Subject: Rezoning Petition Review

Date of Review: January 25, 2022 *(Revised February 25, 2022)*

Rezoning Petition #: 21-206

Location of Property: Approximately 4.20 acres located on the west side of N Tryon St, east of I-85 and south of W Mallard Creek Church Rd.

REZONING PETITION 2021-206  
RZ-2 : TECHNICAL DATA SHEET

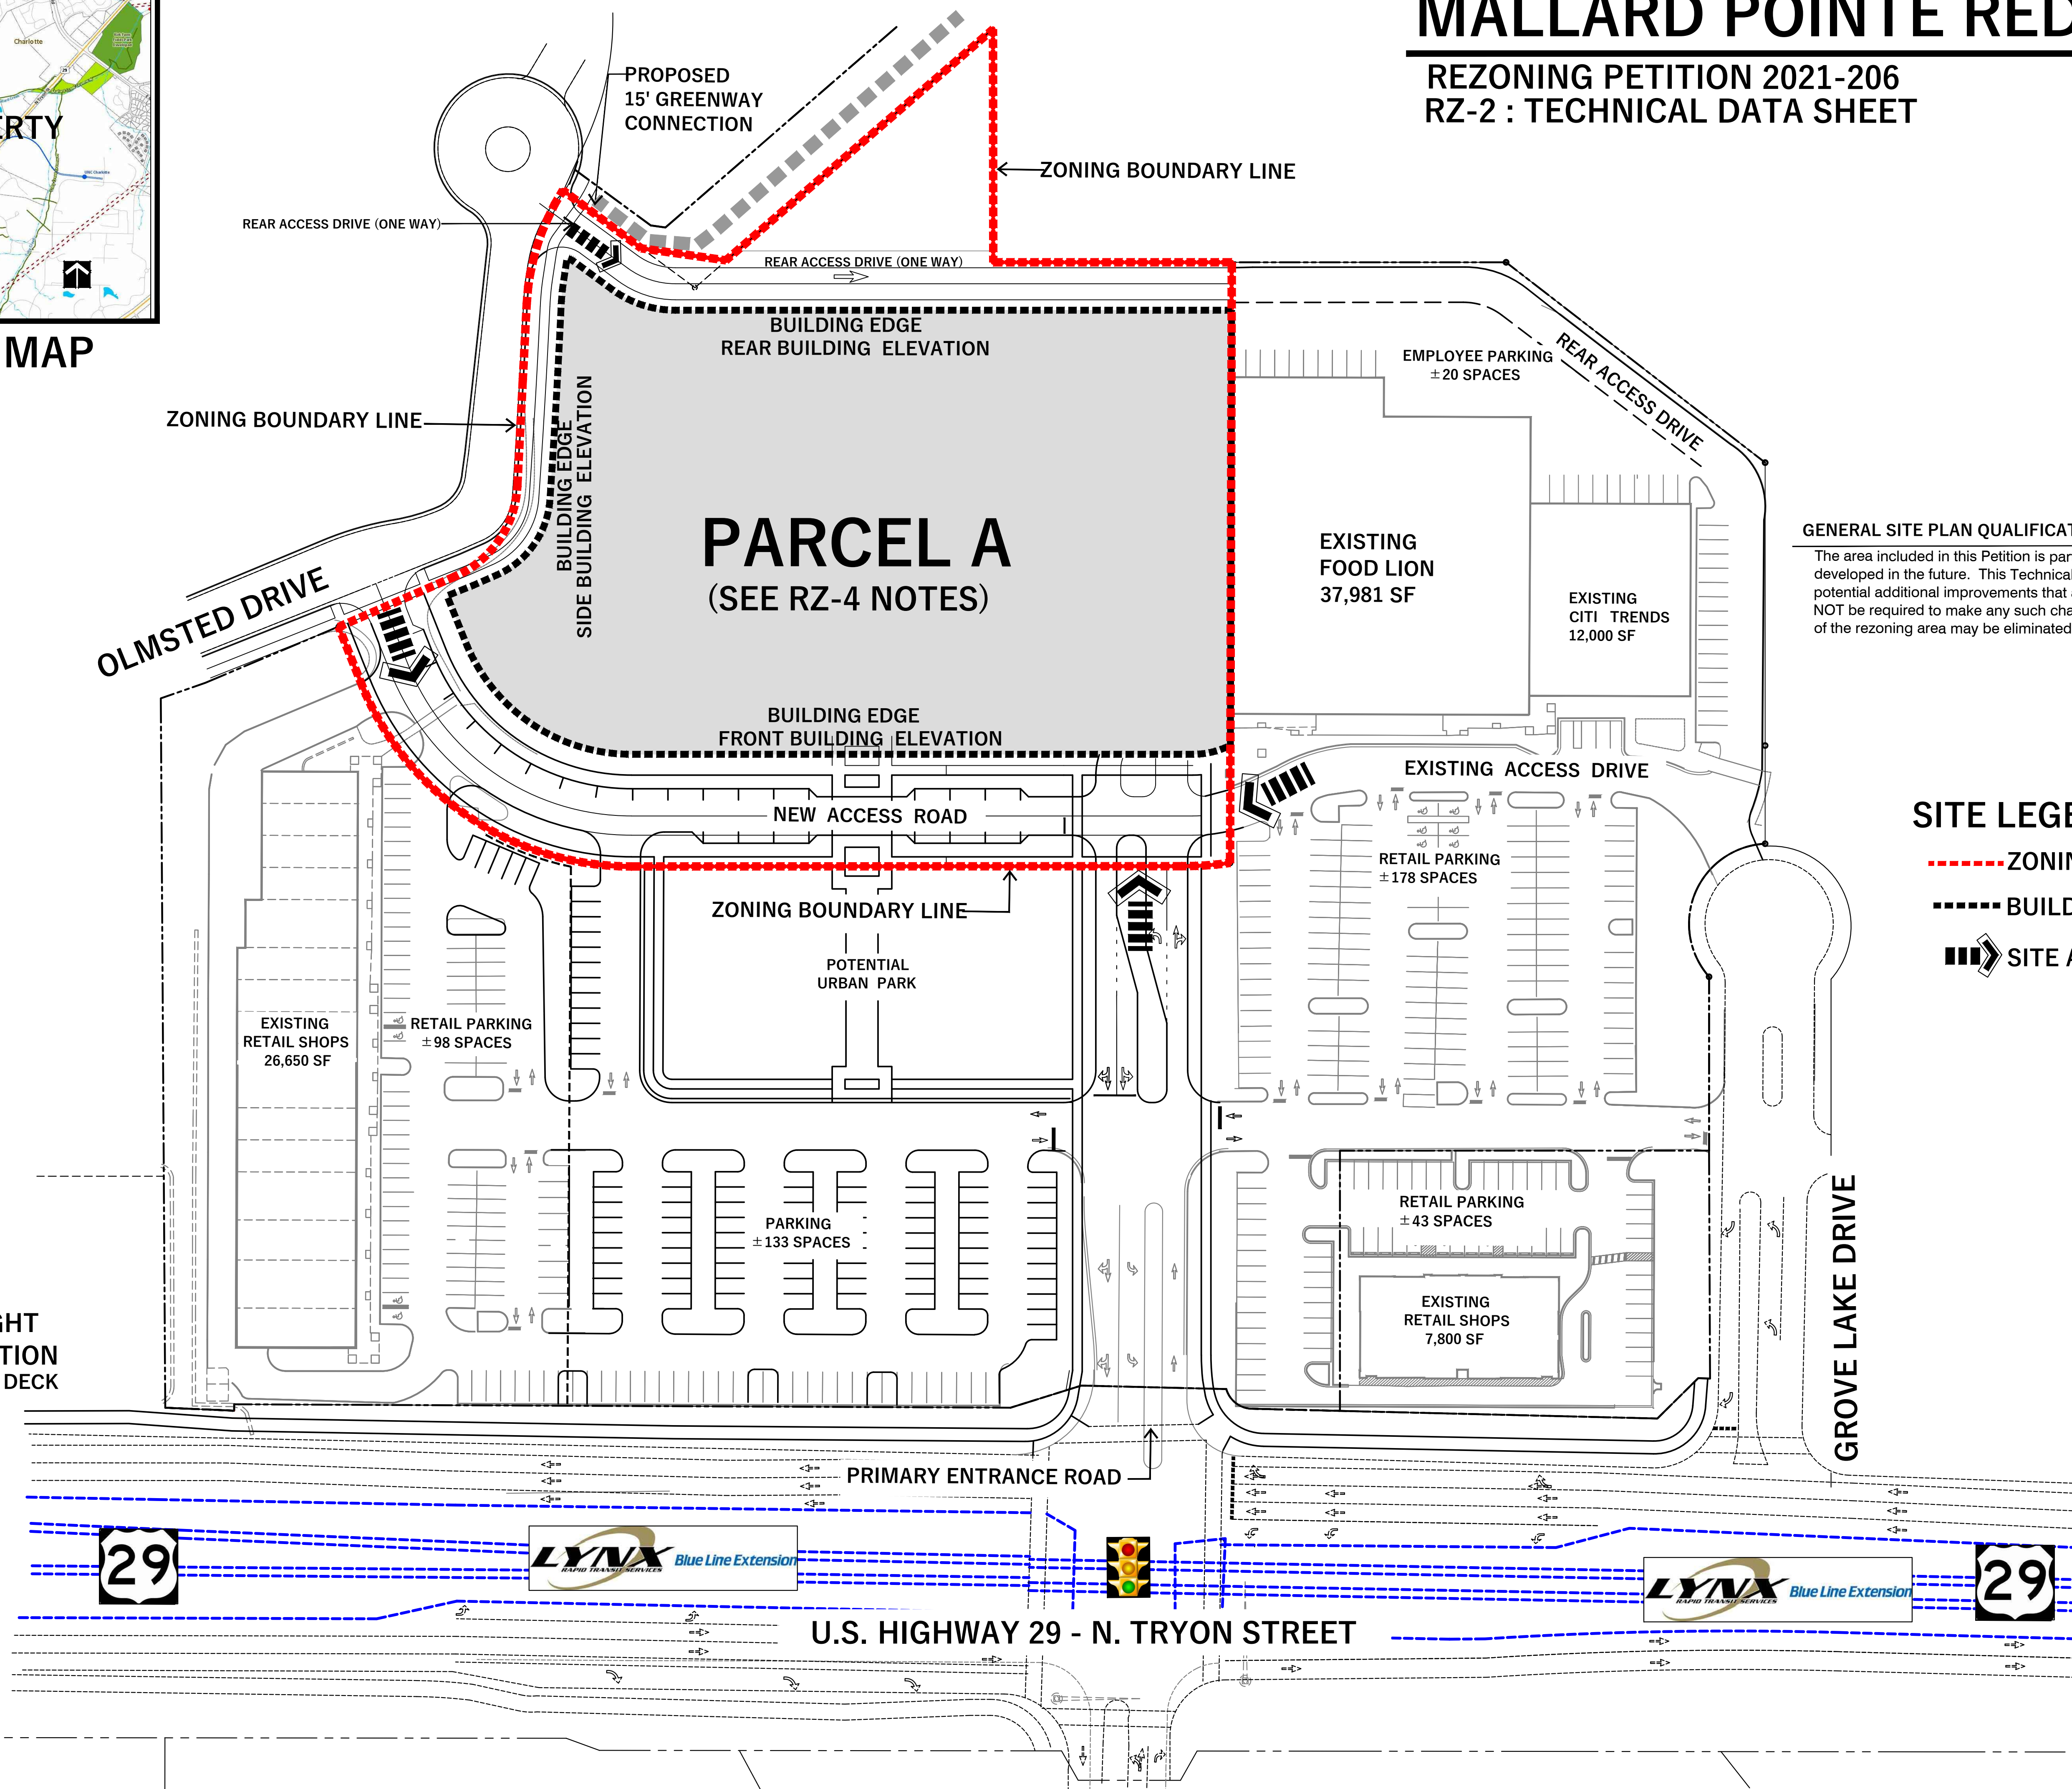
Please remove note 5a in its entirety as this is not determined or approved during the rezoning process.

(I) Storm Water Quality Treatment

For defined watersheds greater than 10% built-upon area (BUA), construct water quality stormwater control measures (SCMs) designed for the runoff generated from the first 1-inch of rainfall for all new and redeveloped BUA associated with the project. SCMs must be designed and constructed in accordance with the Charlotte-Mecklenburg BMP Design Manual.

(II) Volume and Peak Control

For defined watersheds greater than 10% built-upon area, control the entire volume for the 1-year, 24-hour storm for all new and redeveloped BUA associated with the project. Runoff volume drawdown time shall be in accordance with the Charlotte-Mecklenburg BMP Design Manual.

For commercial projects with greater than 10% BUA, control the peak to not exceed the predevelopment runoff rates for the 10-yr, 6-hr storm and perform a downstream flood analysis to determine whether additional peak control is needed and if so, for what level of storm frequency, or if a downstream analysis is not performed, control the peak for the 10-yr and 25-yr, 6-hour storms.

For residential projects with greater than 10% BUA, control the peak to not exceed the predevelopment runoff rates for the 10-year and 25-year, 6-hour storms or perform a downstream analysis to determine whether peak control is needed, and if so, for what level of storm frequency.
